# DRAINAGE LETTER

## 11925 MILAM ROAD

SUBJECT: Drainage Letter  
11925 Milam Road

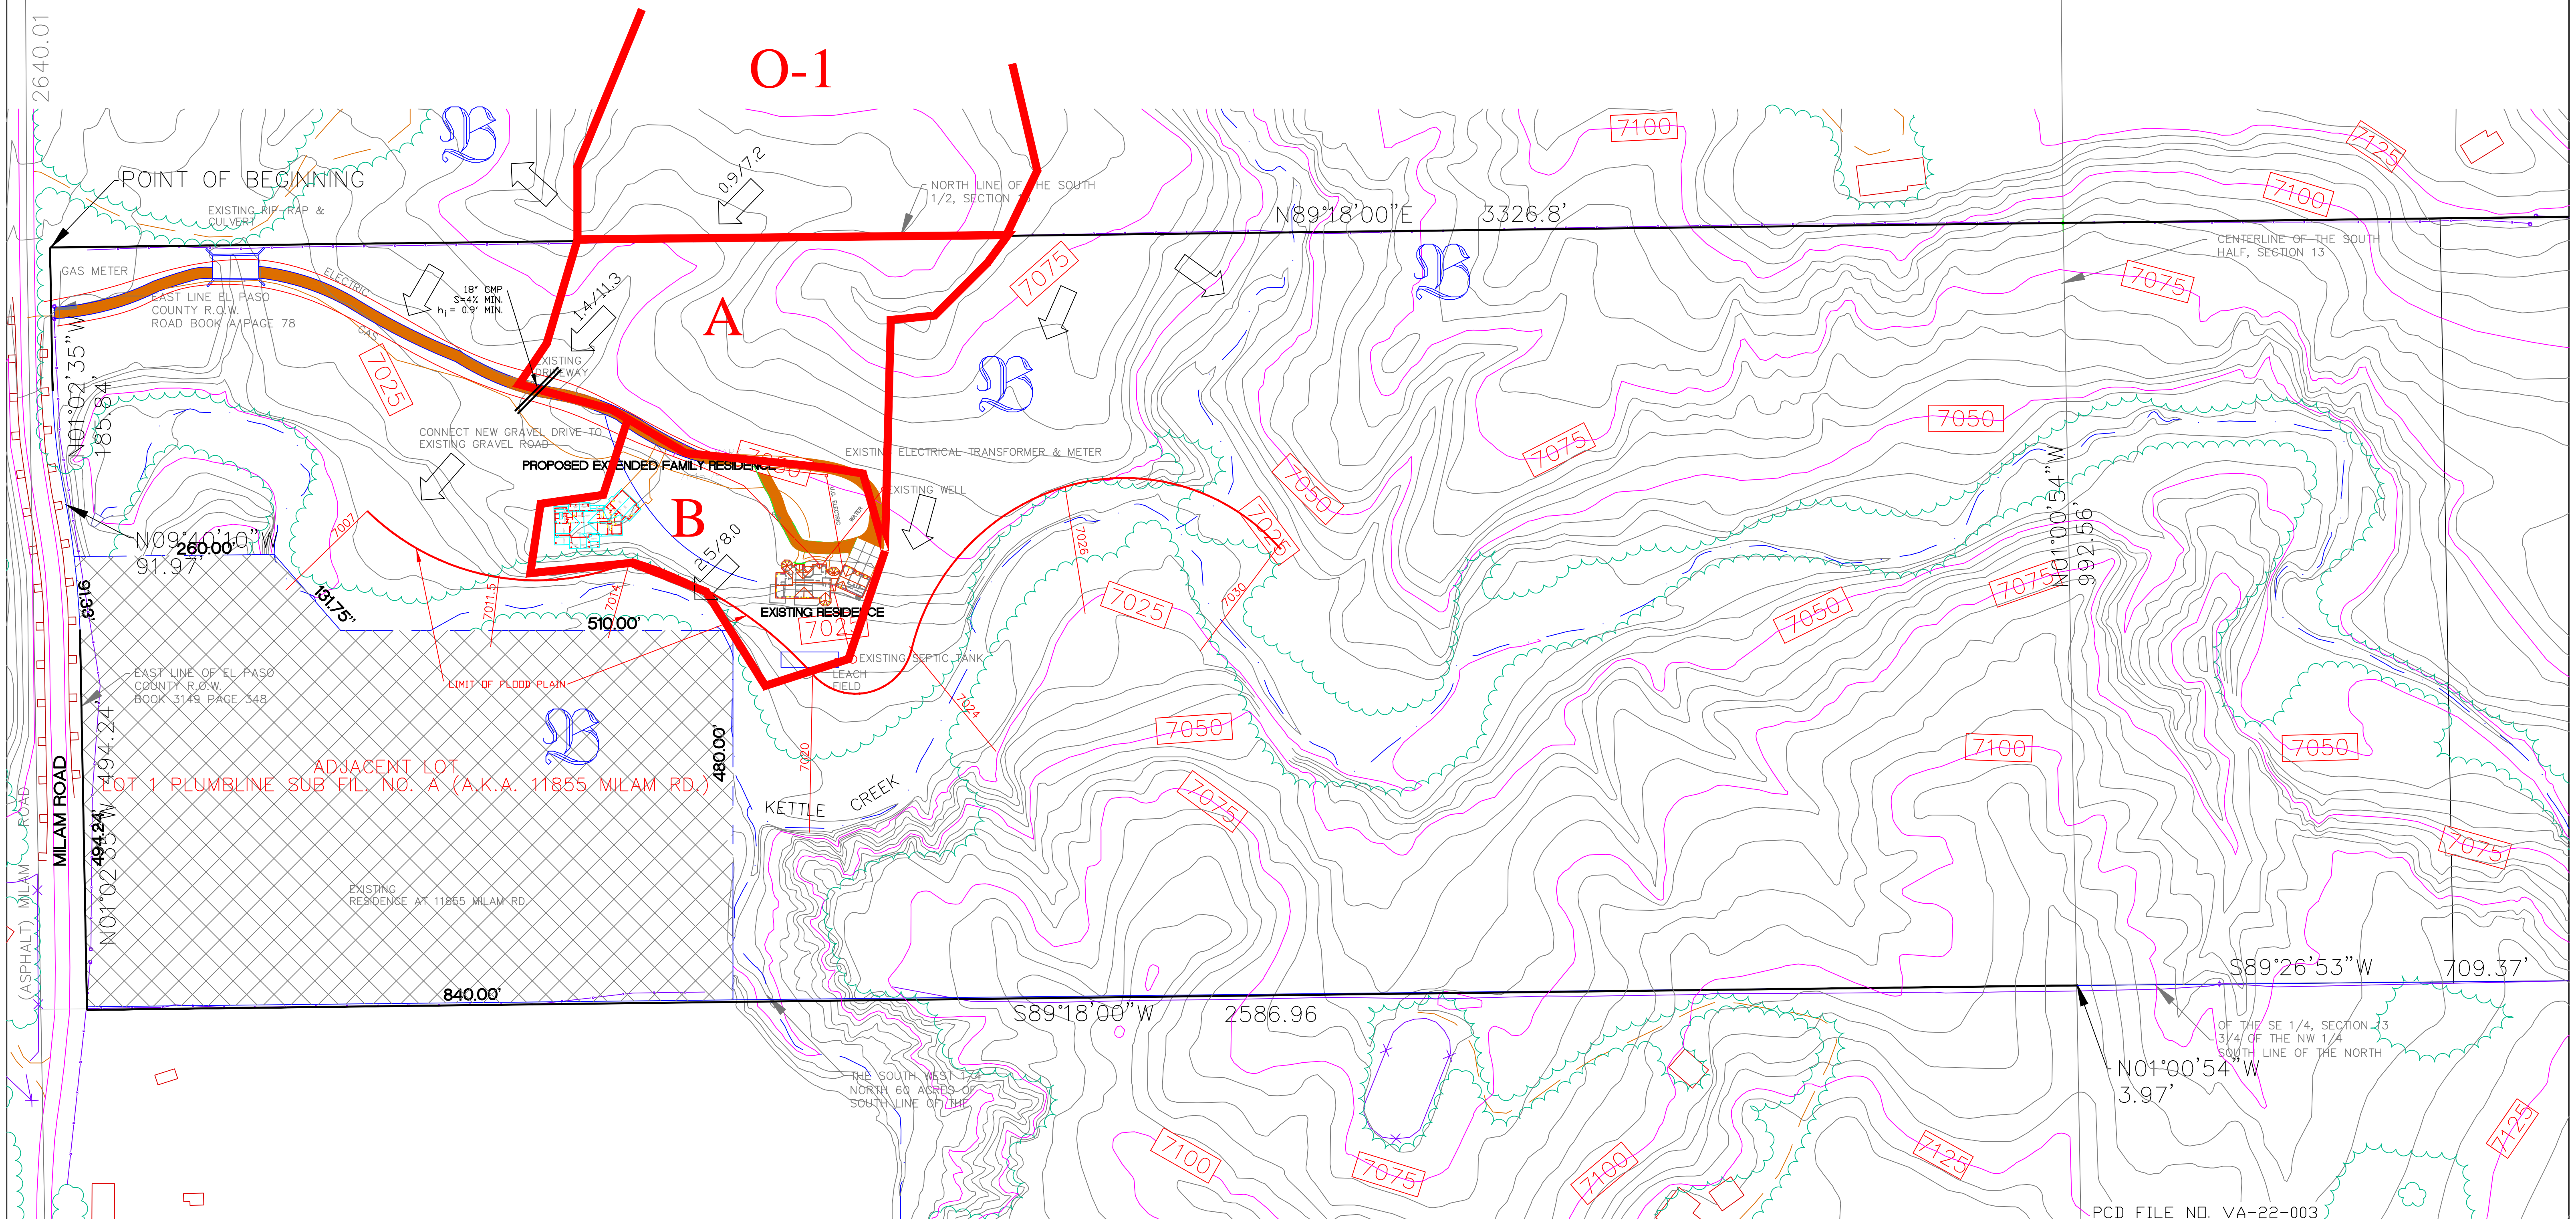
Please add applicable label proposed/existing to drainage plan.

Please add "PCD File No. VA-22-003".
